Our Ref: EN010077

Date: 22 November 2019

Application by ScottishPower Renewables for an Order Granting Development Consent for the East Anglia ONE North Offshore Wind Farm

Advice following issue of decision to accept the application for examination

East Anglia ONE North Offshore Wind Farm			Drg No	180476_PLN_DCO_1820.5	
Land Plans (Onshore)			Rev	04	British National Grid OSGB36
Sheet Number: Sheet 5 of 12			Date	01/03/2021	
			APFP Ref: 5(2)(i)		Doc ref: 2.2.2

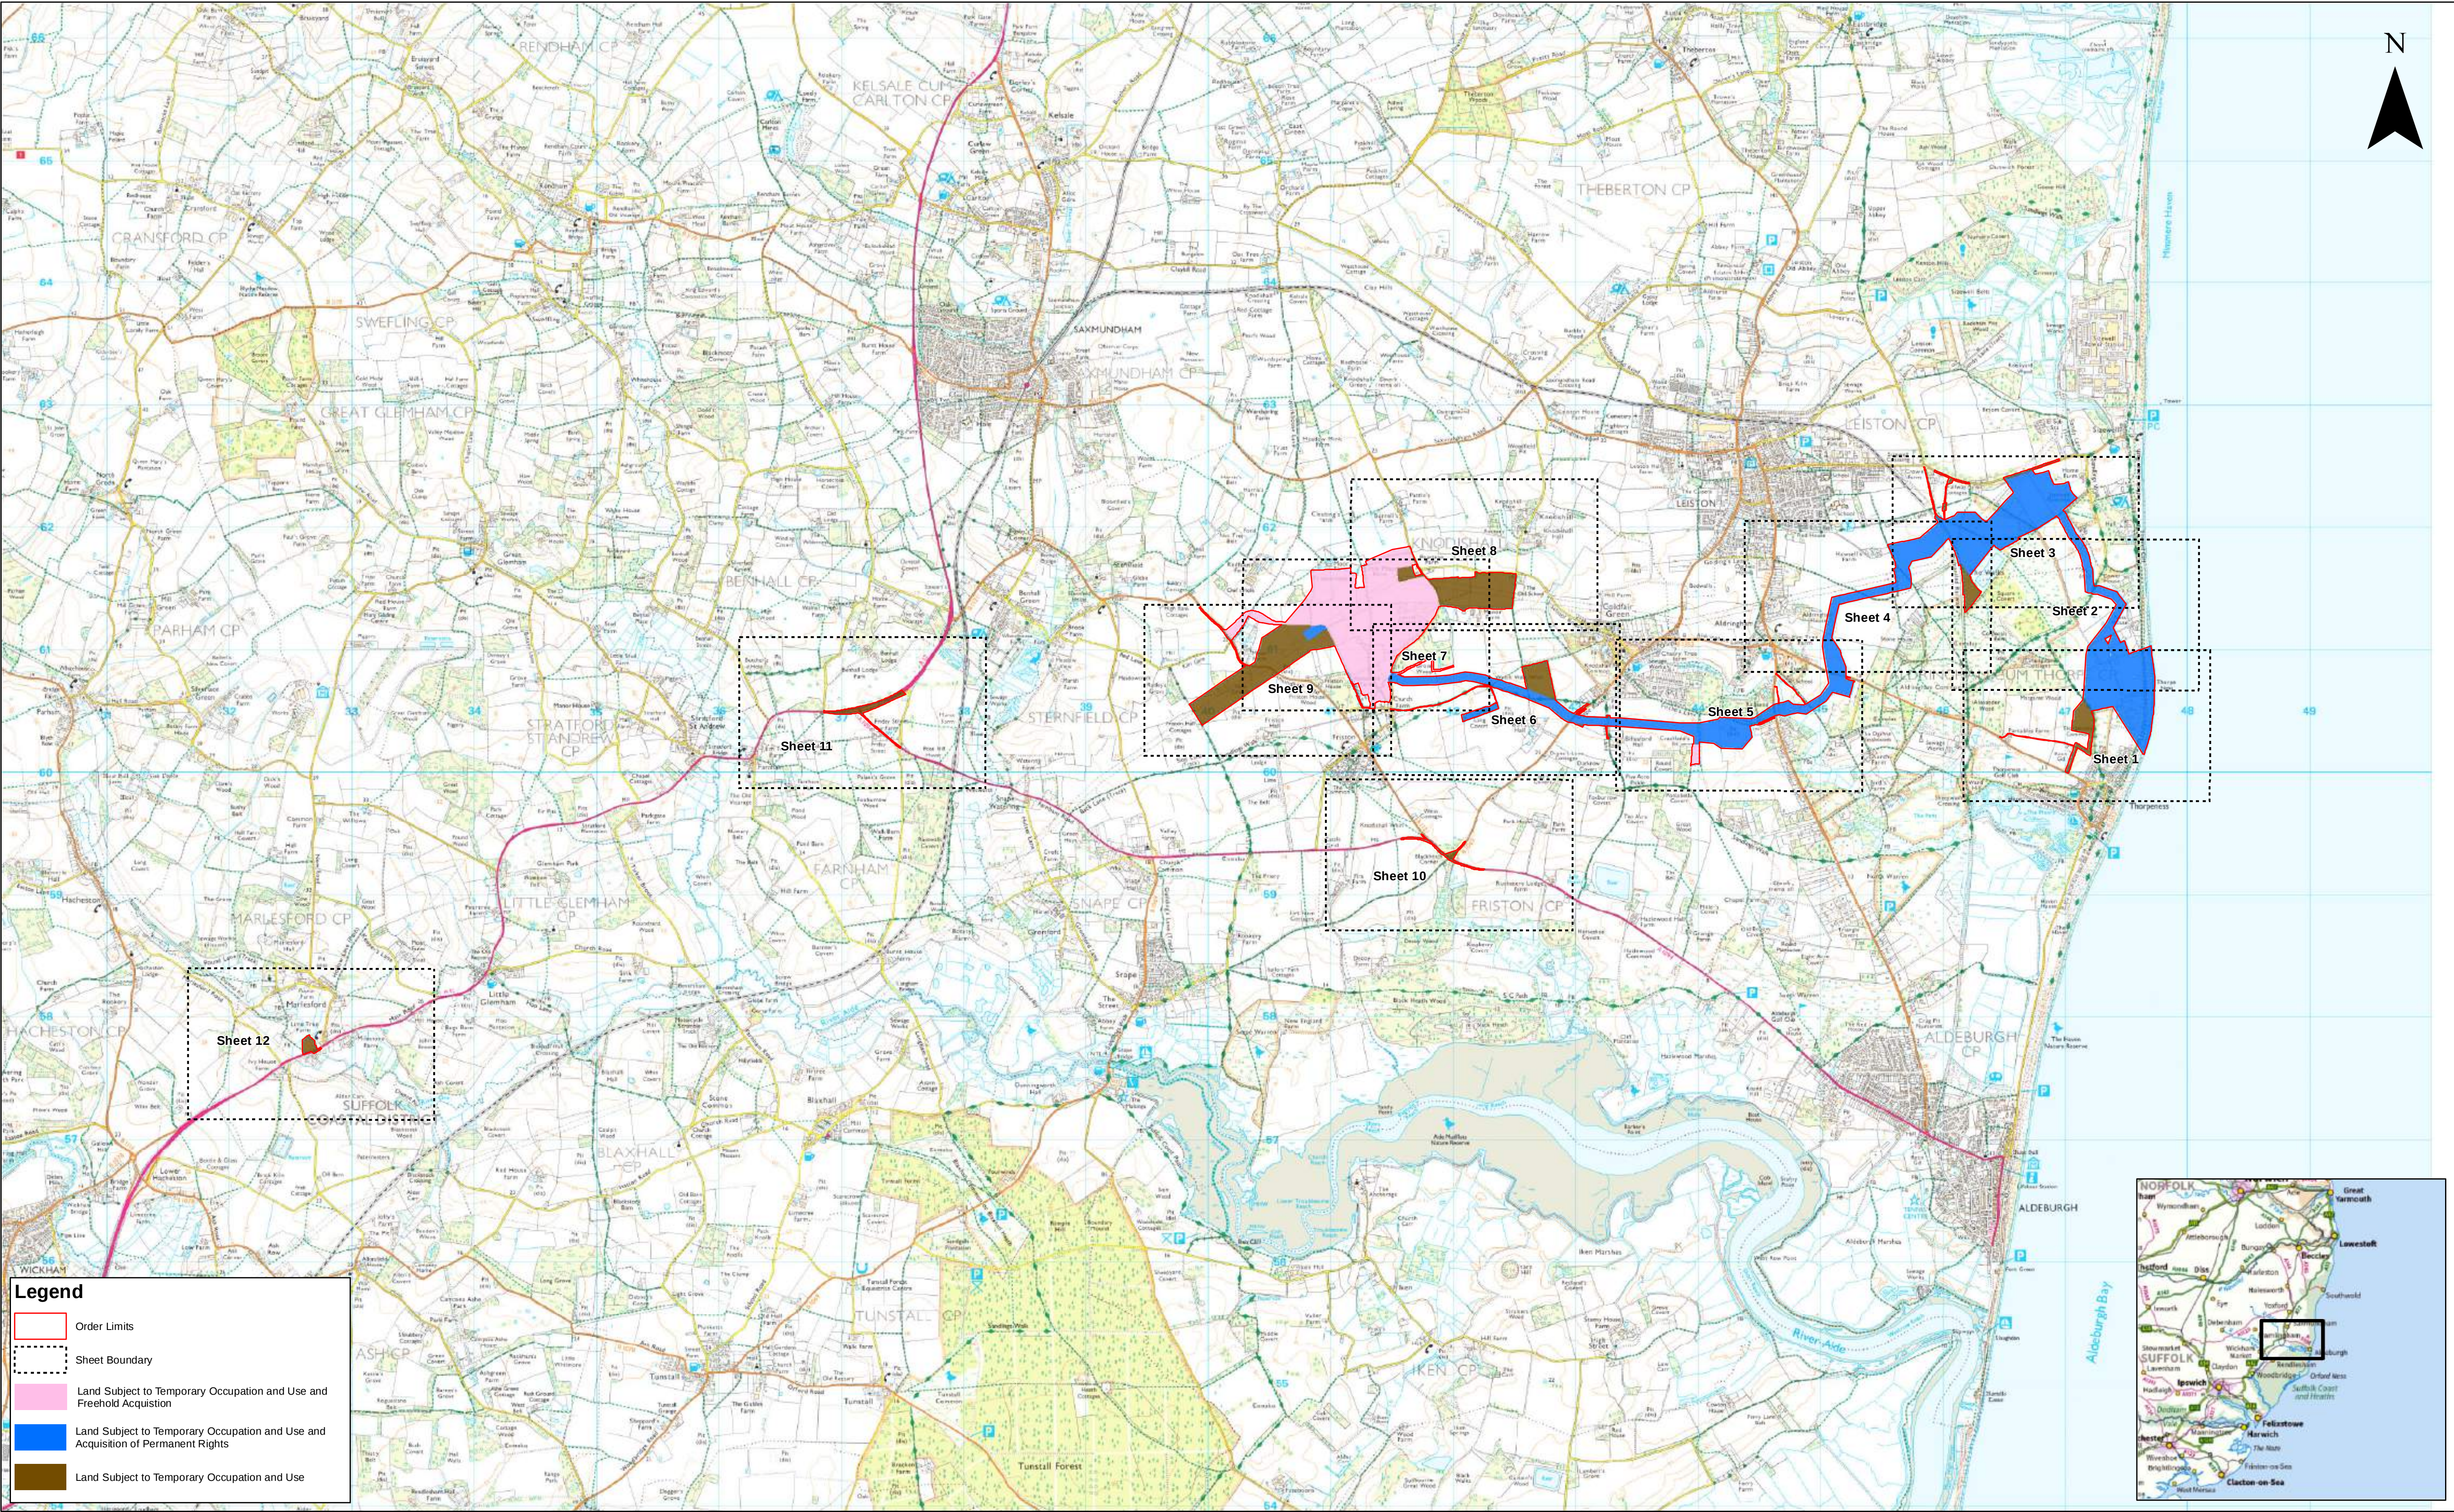
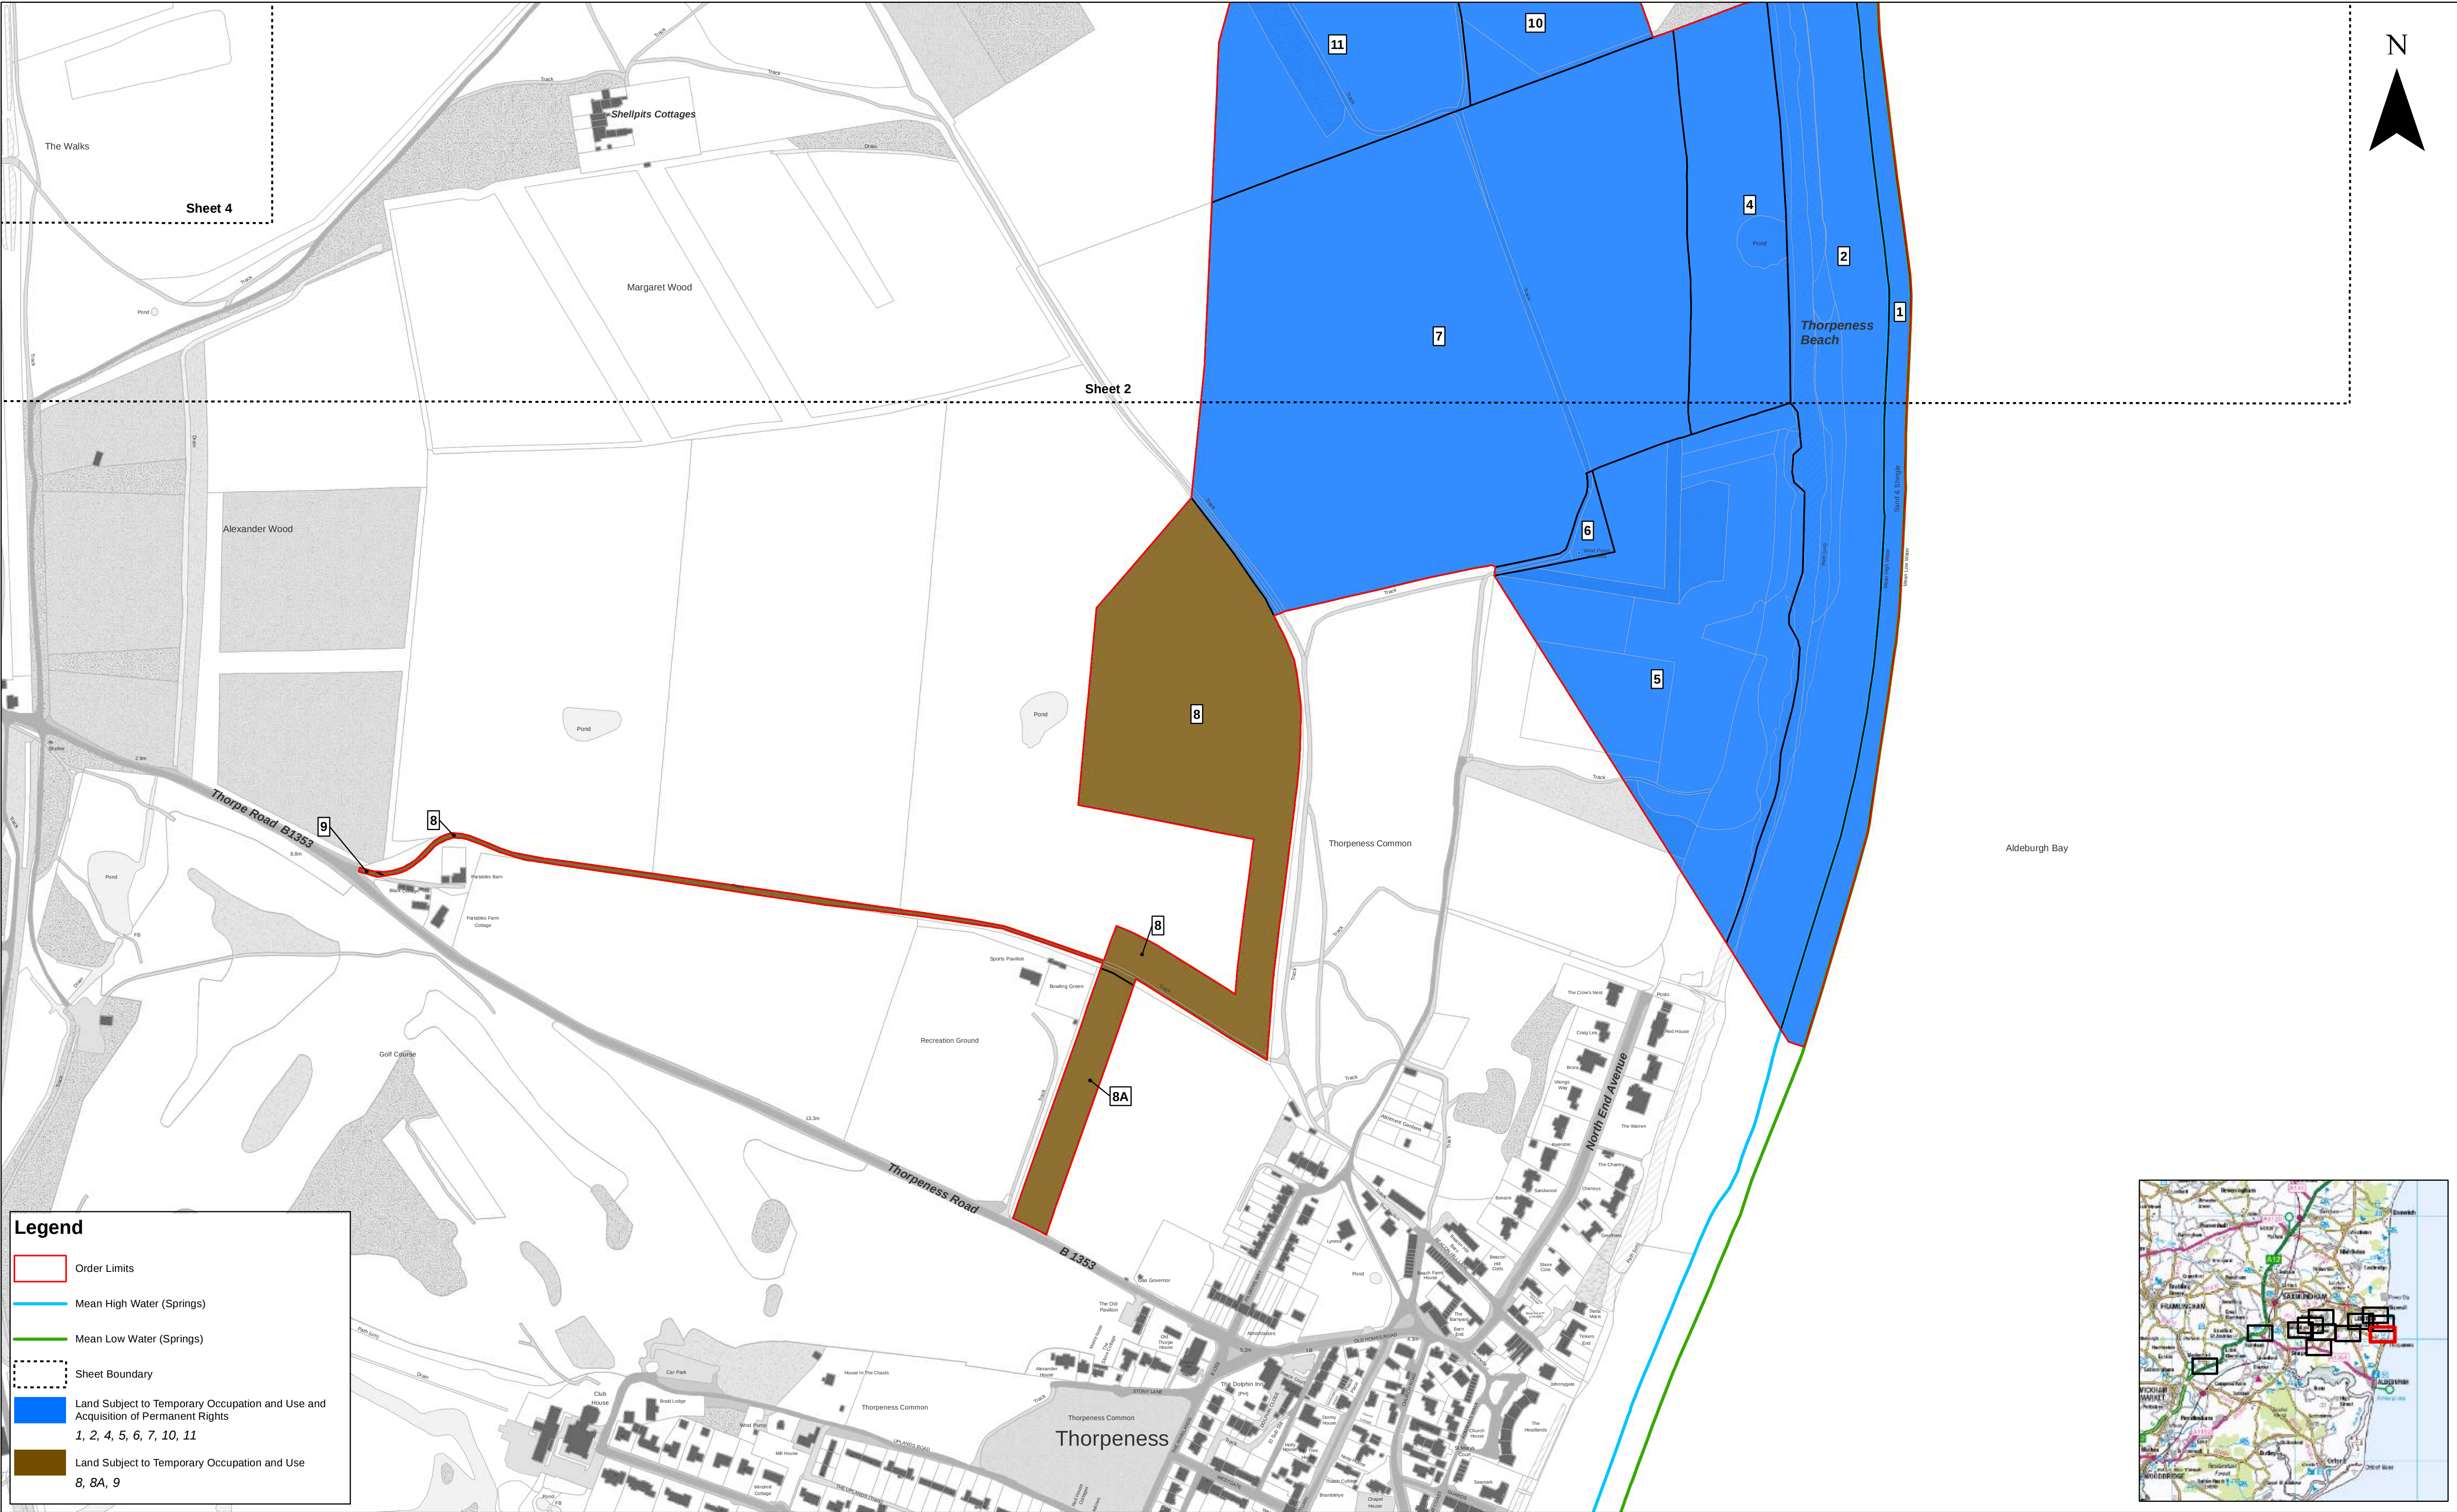
The Applicant is advised to carry out a full check of the BoR to ensure all information provided is complete and accurate. An introduction to the document may aid the reader. Although this is not formally required to comply with the legislation or Guidance, such an introduction has been included in some recent applications. Please provide updated Land Plans which include:

- The names of all relevant landmarks described in Column 2 ('Extent of acquisition or use') of the BoR (e.g. Sizewell Estate, Sizewell Gap, Grimsey's Lane, Blackheath Estate, Redhouse Farm and Knodishall Hall) should also be shown on the relevant Sheets of the Land Plans.

- Road names on the Land Plans to assist the identification of land should be shown more clearly.
- Larger and clearer landmarks on the relevant Sheets of the Land Plans.

- The same map base as the other submitted plans and sheet layout. (It was noted in the checklist that the Land Plans have used a different map base to the other submitted plans, and this makes comparison between the Land Plans and the other submitted plans more difficult than it needs to be.)

- Additional insets. (It was noted in the checklist that Plots 18, 91 and 126 would benefit from being shown on an inset plan.)
- Corrected Plot number for inset 9.4.
